**Our ref:** WX/2018/132154/01-L01  
**Your ref:** TR010036  
**Date:** 18 October 2018

### **A303 SPARKFORD TO ILCHESTER DUALLING SCHEME DEVELOPMENT CONSENT ORDER**

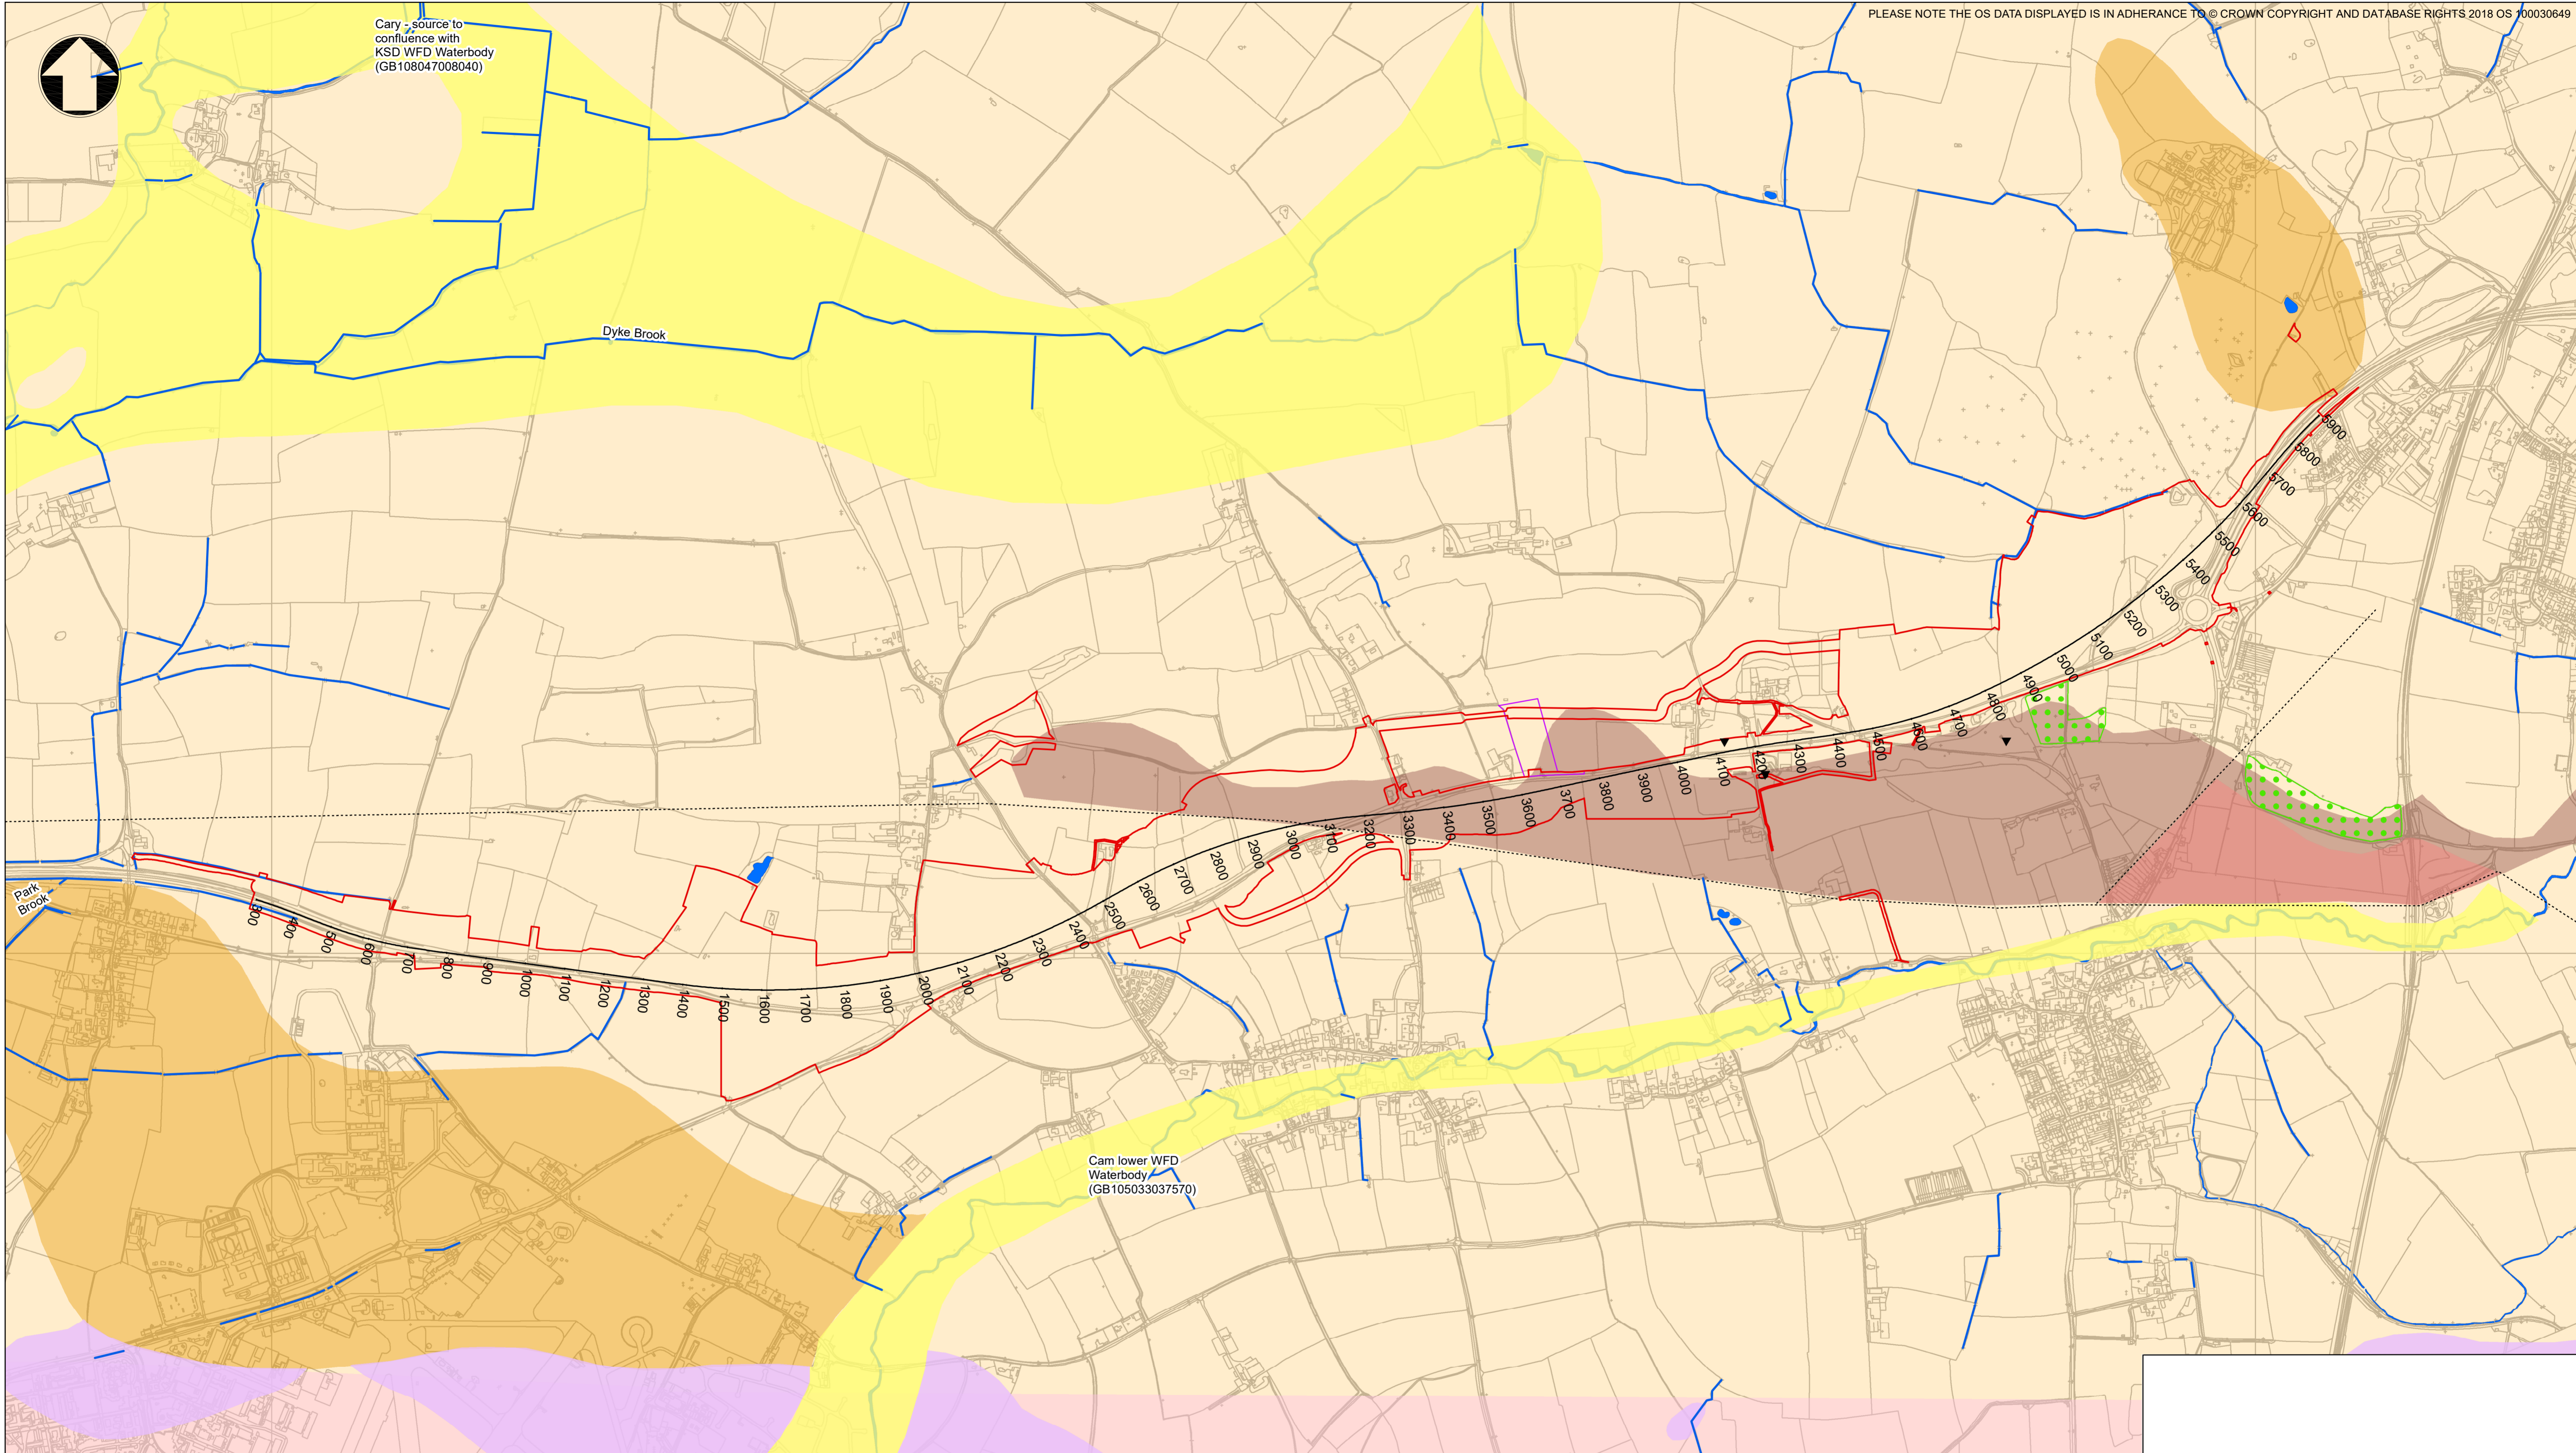
Chapter 9 (Geology and Soils) of the Environmental Statement also fails to consider unlicensed groundwater abstractions. Whilst we agree that there are no Source Protection Zones attributed to public water supplies in the vicinity of the scheme, there are likely to be default 50m radius SPZ1 around private abstractions within the area of study.
